# BUILDING PERMIT

Job ID: 2011-10-2360-SIGN

has permission to Install 16" x 32" hanging sign

39" Bracket
5/8" square arm
3" back plate
4" Spear point
hooks are 22" apart
Install included

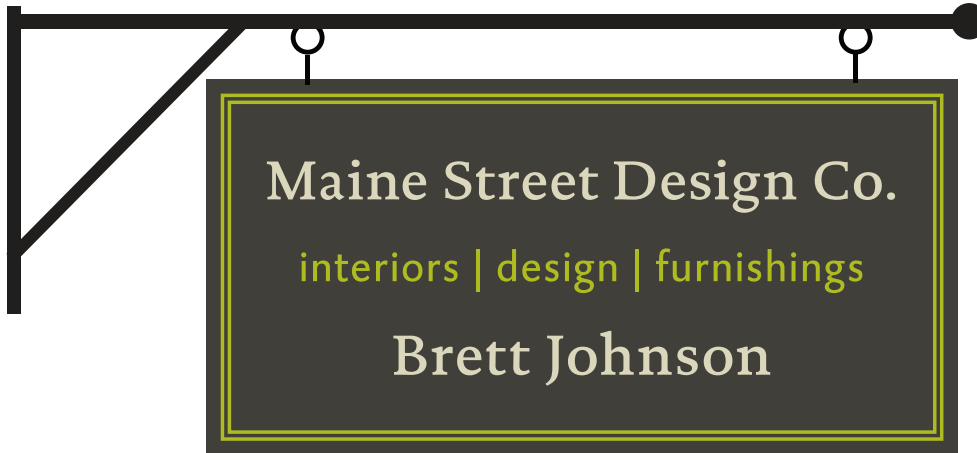
1. Sign location to be as shown on "street façade" view, not on mocked up photo.
2. No provisions for sign lighting are included with this application. If lighting is desired, fixtures must be incorporated into the bracket, with no exposed conduit. Final approval of lighting must be received from HP staff.
3. The scissor gate at the storefront shall be removed as this was installed after the building became a part of the Congress Street Historic District.

The changes are fine. We have approved guy wires, but I really don't think they're necessary in this instance. Also, the scissor gate that is shown in front of the storefront was installed after the building became part of the Congress Street Historic District. I've been meaning to let the property owner know it needs to be removed. Could you discuss this with the applicant? I meant to address it in my sign-off, but forgot.
